WEST SUSSEX COUNTY COUNCIL CONSULTATION

TO:	Arun District Council FAO: Simon Davis
FROM:	Stephen Gee WSCC - Highways Authority
DATE:	25 January 2022
LOCATION:	10 Acre Field Grevatts Lane West Yapton Bognor
SUBJECT:	<u>Y/184/21/DOC</u> Approval of details reserved by condition imposed under ref W/4000394 (Y/103/18/PL) relating to Condition Nos 5 - Construction & Environmental Management Plan, 8 - surface water drainage, 9 - discharge flows to watercourses, 10 - maintenance & management of surface water drainage, 12 - monitoring regime, 13 - landscaping, 14 - materials & finishes, 15 - landscape management plan and 20 - external lighting.
DATE OF SITE VISIT:	<u>n/a</u>
RECOMMENDATION:	More Information
<u>S106</u> CONTRIBUTION TOTAL:	<u>n/a</u>

Condition 5 CEMP

Condition 12 – Monitoring Regime

Title
SITE SETUP PLAN

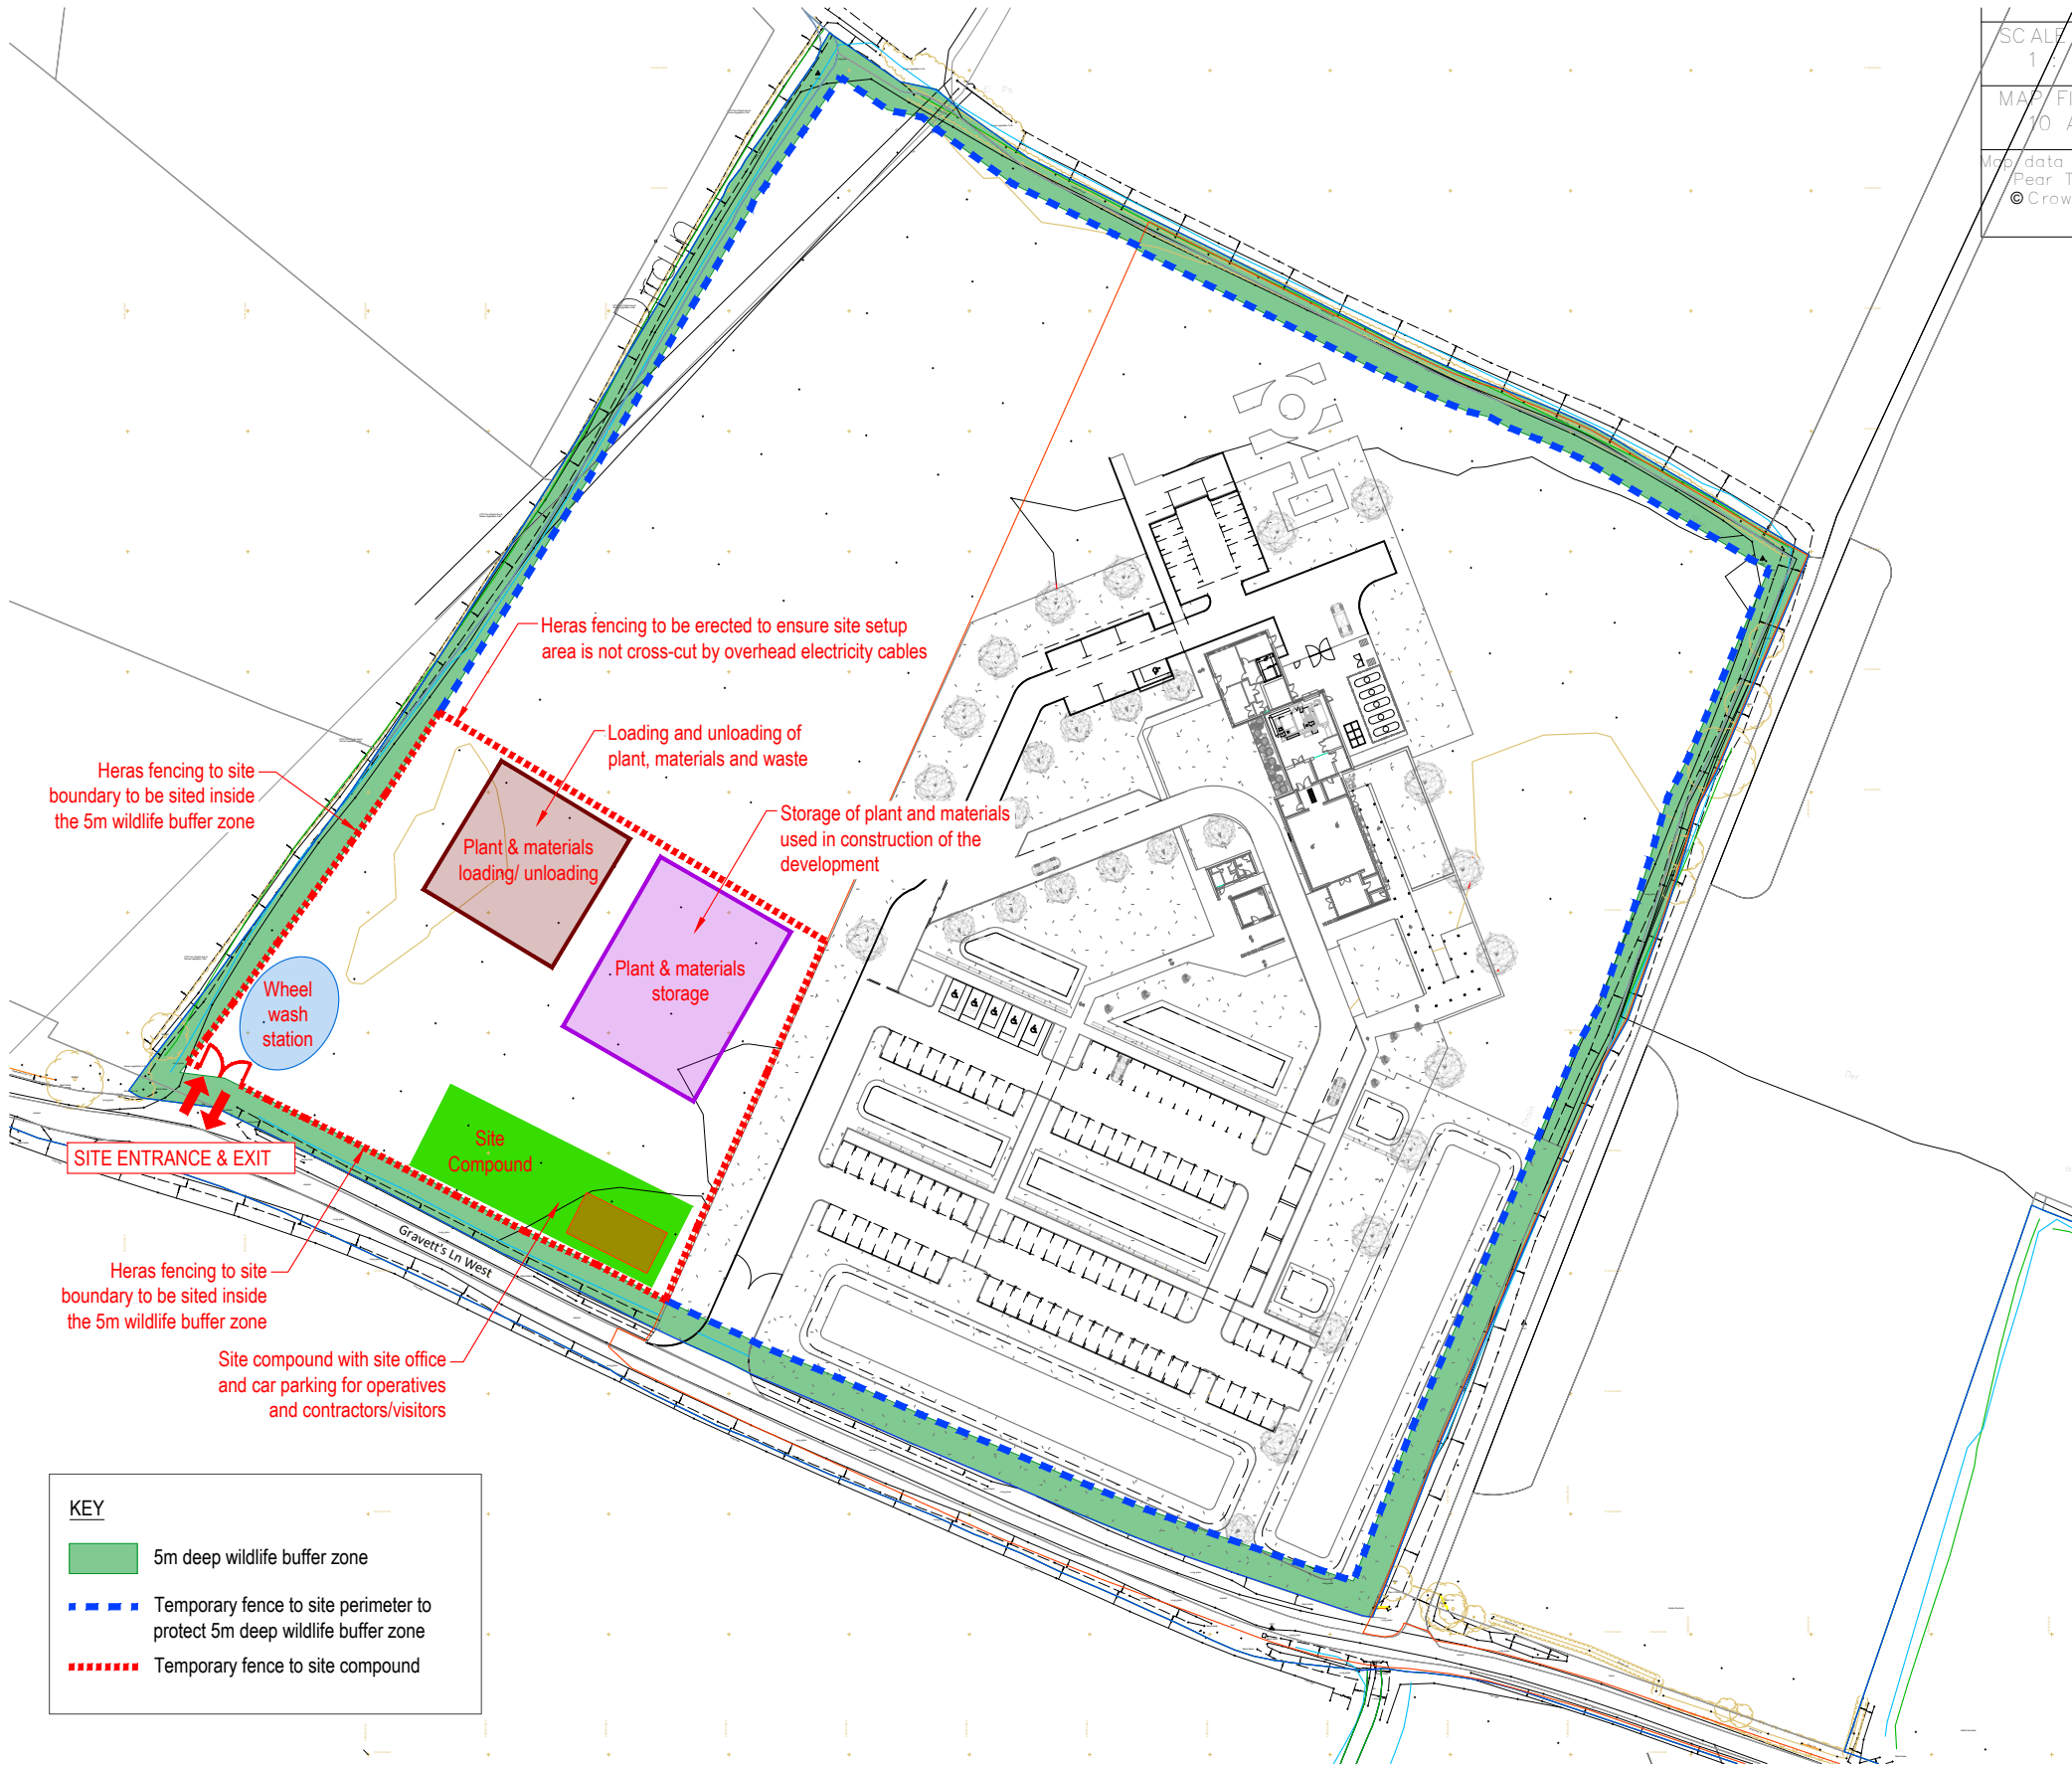
Condition 5 requires details upon (but not limited to):

the anticipated number, frequency and types of vehicles used during construction;

the method of access and routing of vehicles during construction;

The submitted CEMP does not include details on these issues however does highlight a traffic management plan would be produced. This should be provided for assessment.
